Re: Head Height Clearance Issue

Location: Lot 28 McKay Place (Lillington, NC)
JDS Project No.: RDU2503352
Date of Inspection: 04/01/2025

2ND FLOOR I-JOIST PLACEMENT PLAN
DR HORTON - COLUMBIA

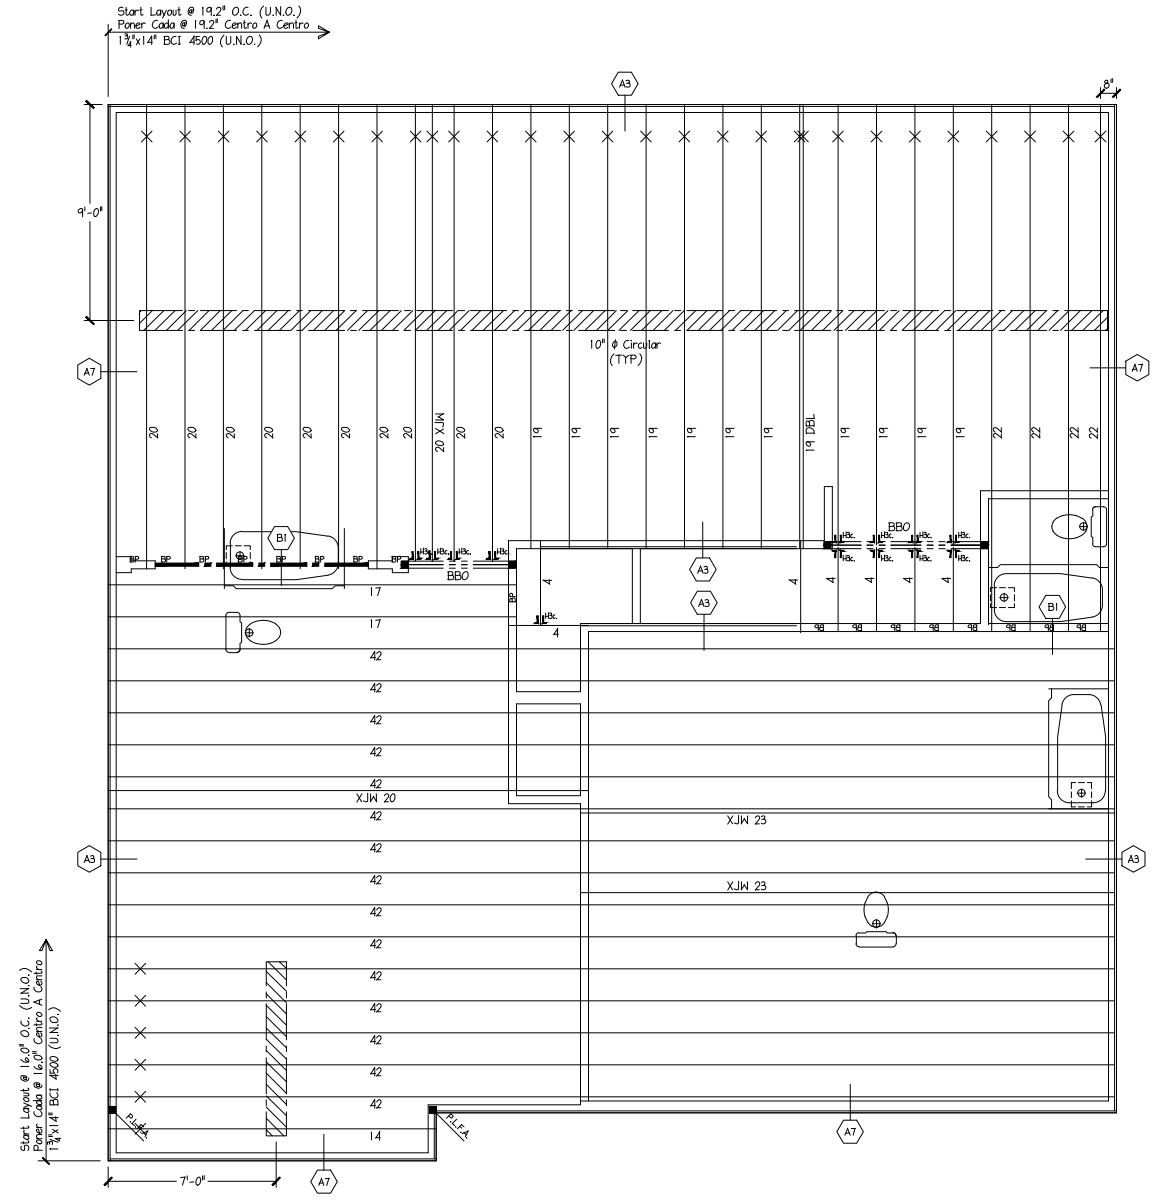
The client requested specifications to solve an issue on site where the clearance between an I-joist and the stairs leaves only approximately 79" rather than the required 80". It was observed on site that the I-joist in question is a 14" deep I-joist spanning approximately 4' across the stairs. The I-joists are spaced approximately 19.2" o.c.

- 1) Remove drywall as necessary and temporarily support the framing.
- 2) Remove the interfering I-joist and replace it with a 2x6 beam of equal length. Install the 2x beam flush to the underside of the floor/wall above by installing vertical 2x blocking cut to the required size in the pockets at each bearing end. Secure the blocking and beam to the surrounding framing with 10d nails.
- 3) To transfer full bearing from the wall above, install an additional 4' long 2x4 to the 2x6 flush along the underside of the flooring, attached with (2) rows of 10d nails.
- 4) Install additional nailing boards as necessary to form new slope for ceiling between 2x6 beam and 14" I-joist.
